**From:** Contact Centre (CRM) <contact@ribblevalley.gov.uk>  
**Sent:** 14 November 2023 15:43  
**To:** Planning  
**Subject:** Planning Application Comments - 3/2023/0735 FS-Case-562026079

**Planning Application Reference No.:** 3/2023/0735

**Address of Development:** 6 Tintern Close  
Simonstone

PROPOSED SIDE ELEVATION

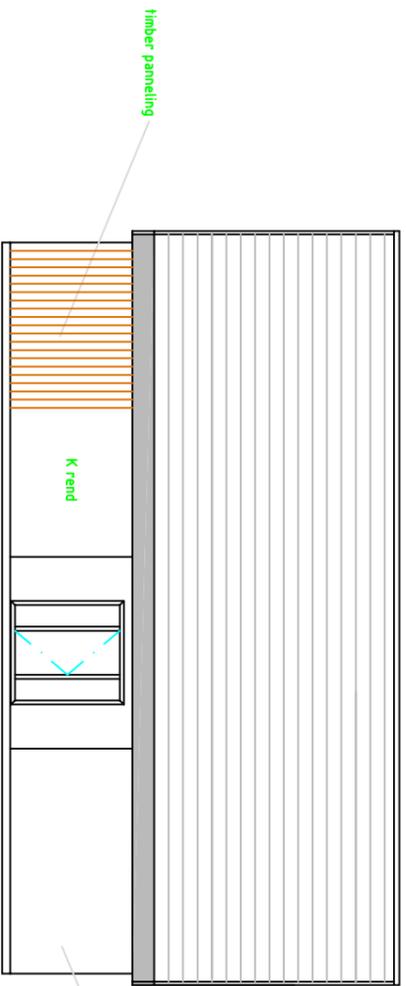
The planned extensions now appear to be smaller than in the first set of plans which were more detailed and certainly resulted in considerable displeasure and anxiety amongst neighbours. Although smaller in size, the side extension will still alter the outlook from the [REDACTED] and privacy will also be affected. Similarly, the plan to park at the [REDACTED] needs to be adhered to without encroachment onto the pavement. There is a long-standing problem with on street parking, particularly on the turning head. I note that in previous and current correspondence the Highways Development Control has stated that this is not acceptable for safety reasons. I can confirm this having had considerable difficulty in severe weather and after dark, risking damage not only to my own vehicle but to those parked on the turning head.
